GLENEAGLE GOLF COURSE RESIDENTIAL INFILL DEVELOPMENT, FILE #2

DRAINAGE, GRADING & EROSION CONTROL PLAN OVERALL

GLENEAGLE SUBDIVISION, FILE #2

DRAINAGE, GRADING & EROSION CONTROL PLAN

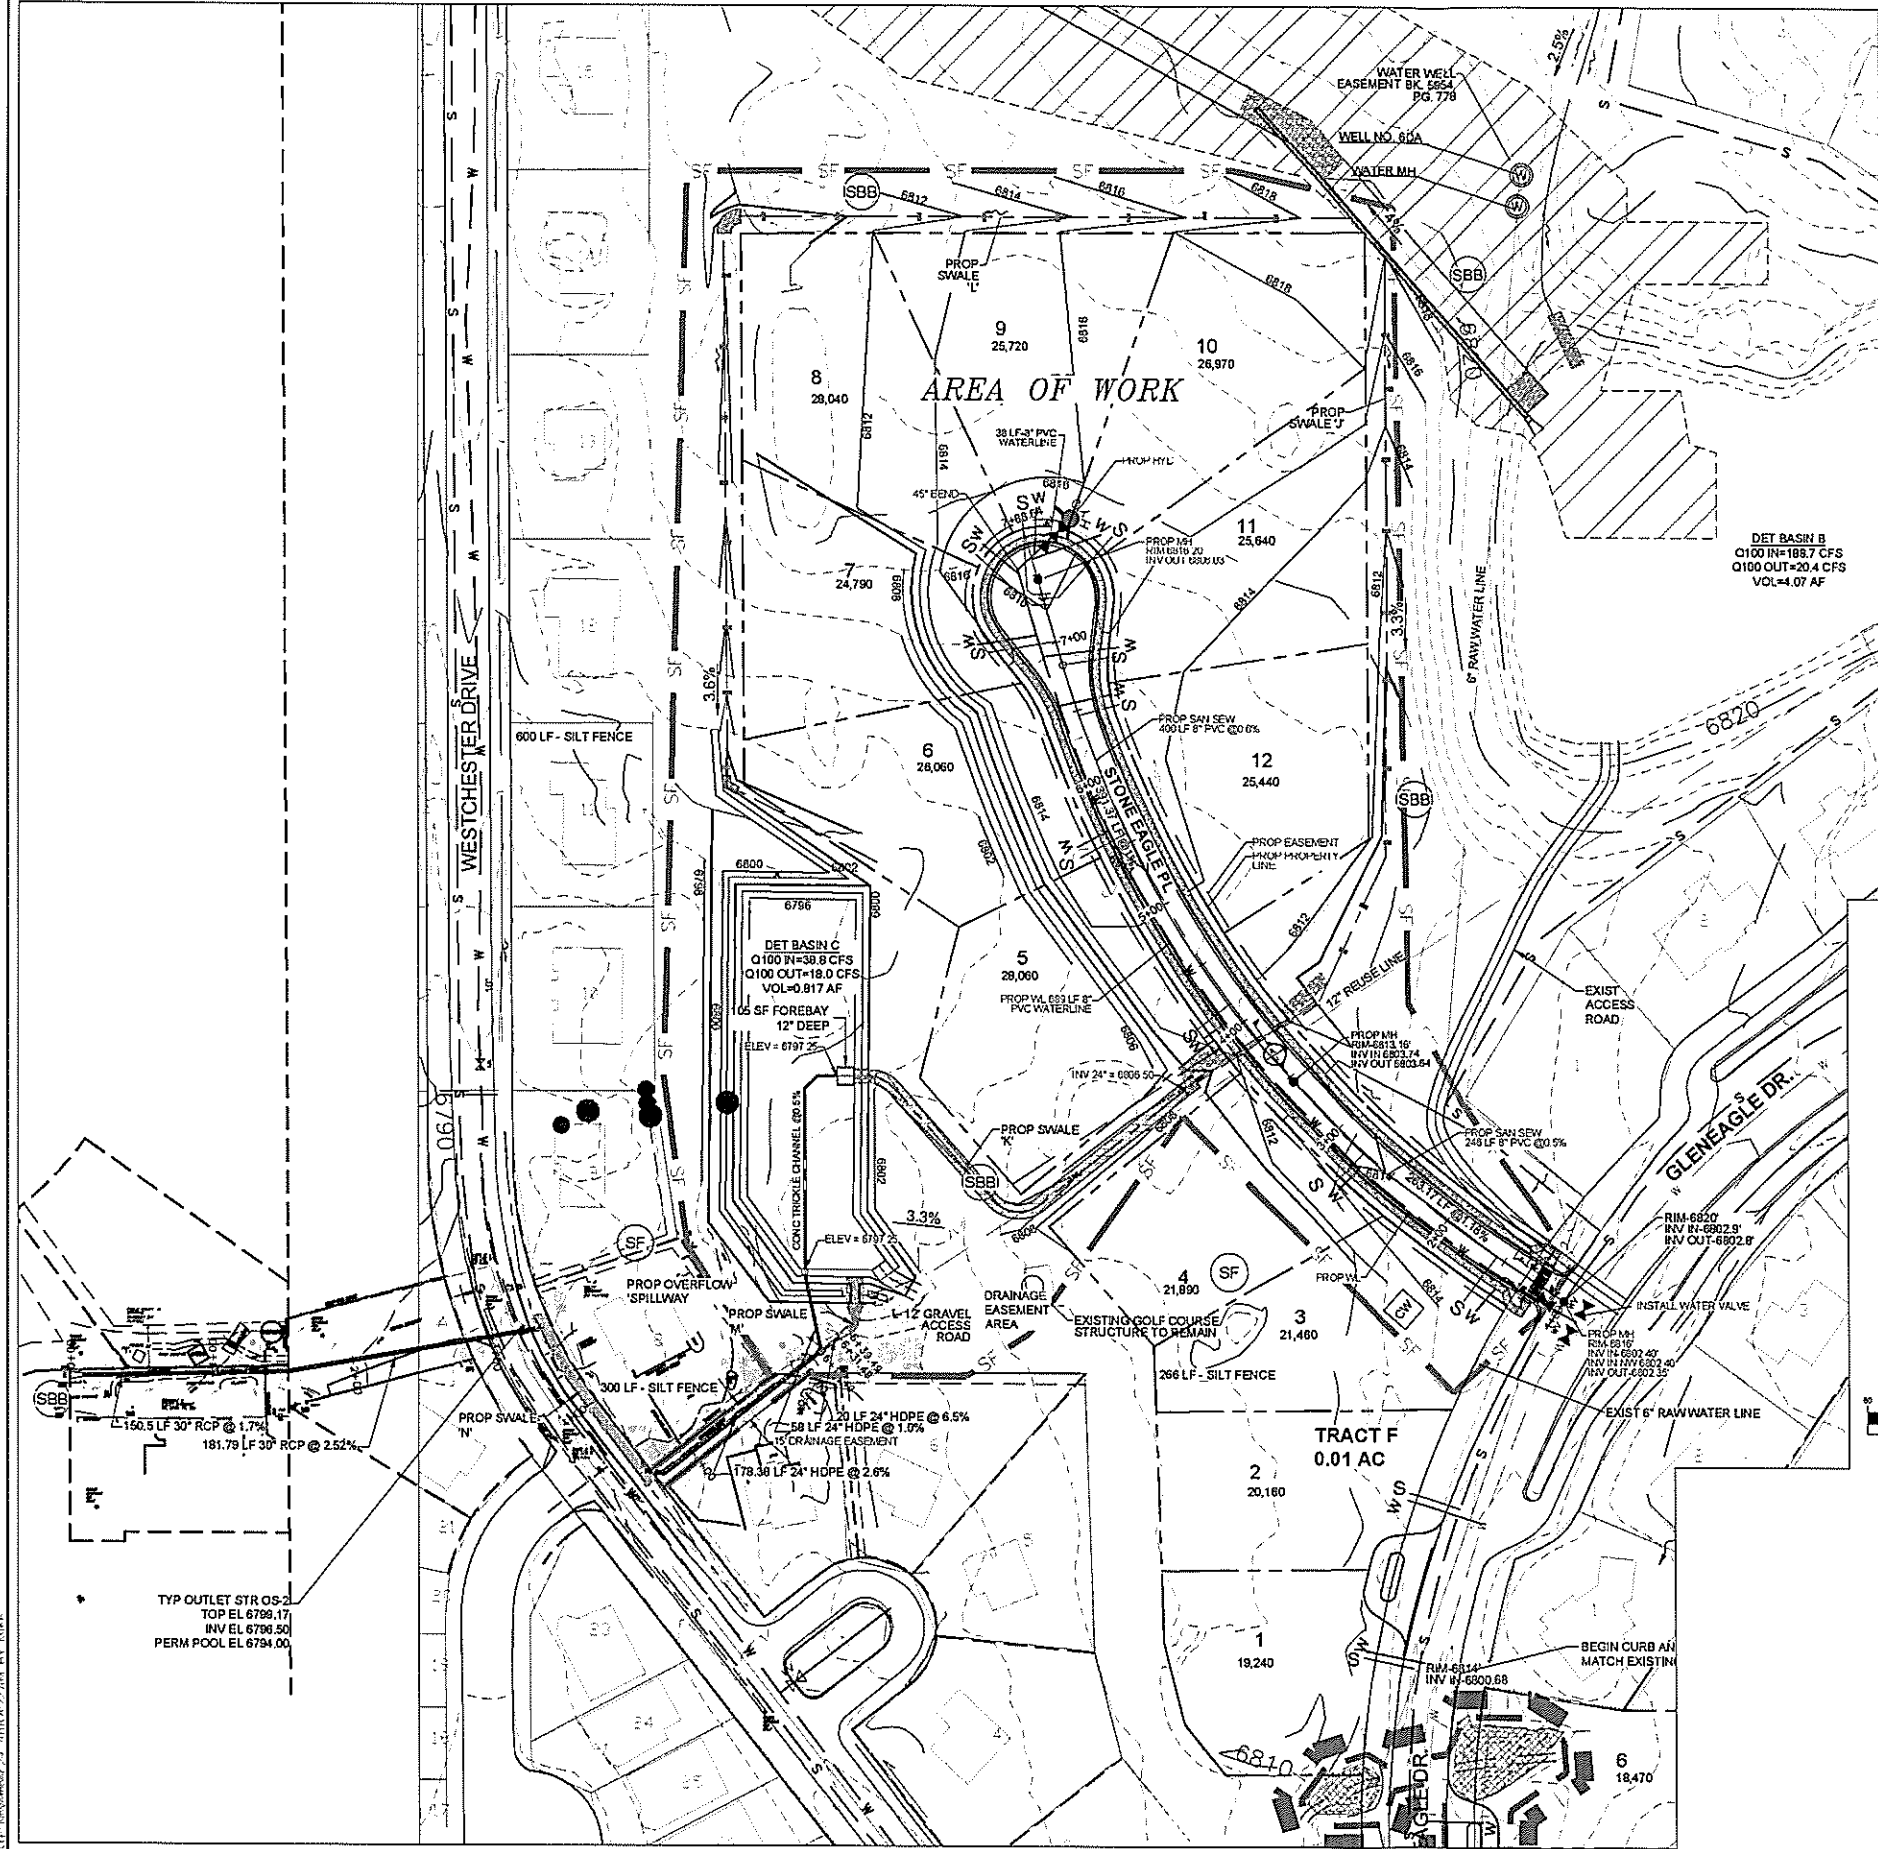
Provide an exhibit that depicts detailed grading and improvements associated with the public storm sewer that crosses these easements. There will need to be berming etc. to keep stormwater off of the private property to the North and others.

Provide some form of erosion checks for the curb and gutter section

Inlet protection?

Show vehicle tracking.

Call out outlet structure

Revise proposed swale to a RCP.

DRAWING NUMBER:
C
 SHEET 3

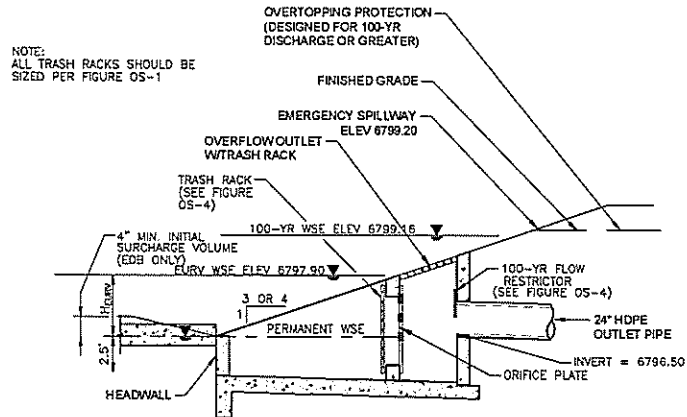
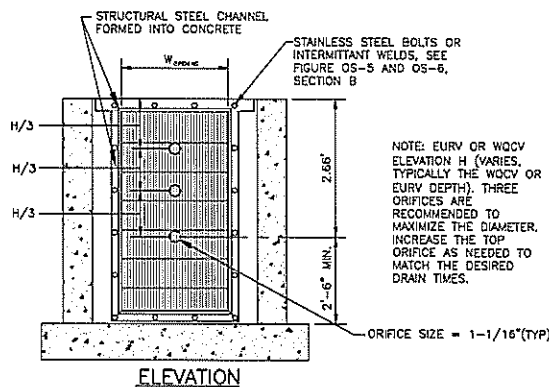
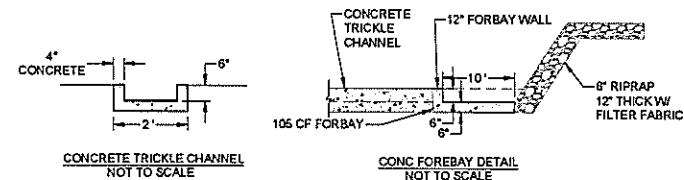
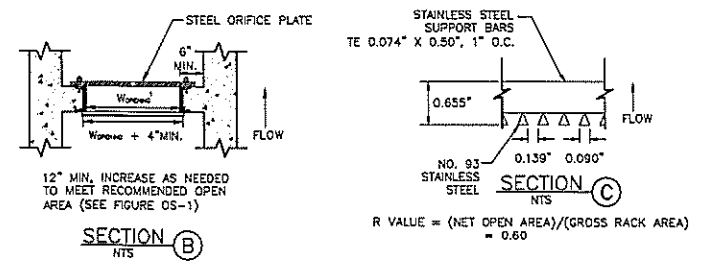
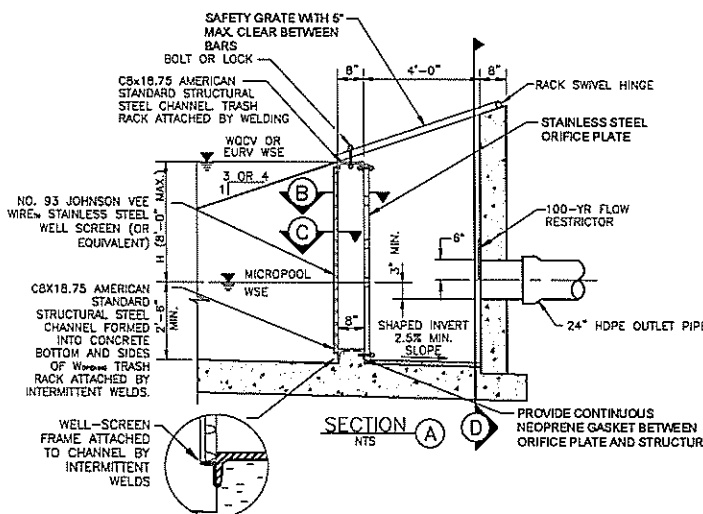
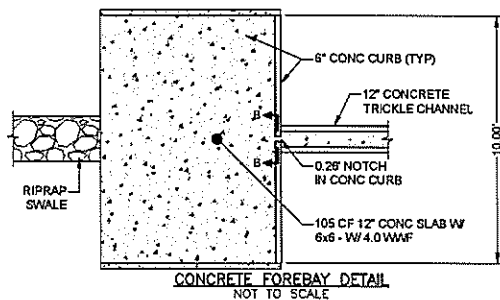
Call out the Width of the Safety Grate.
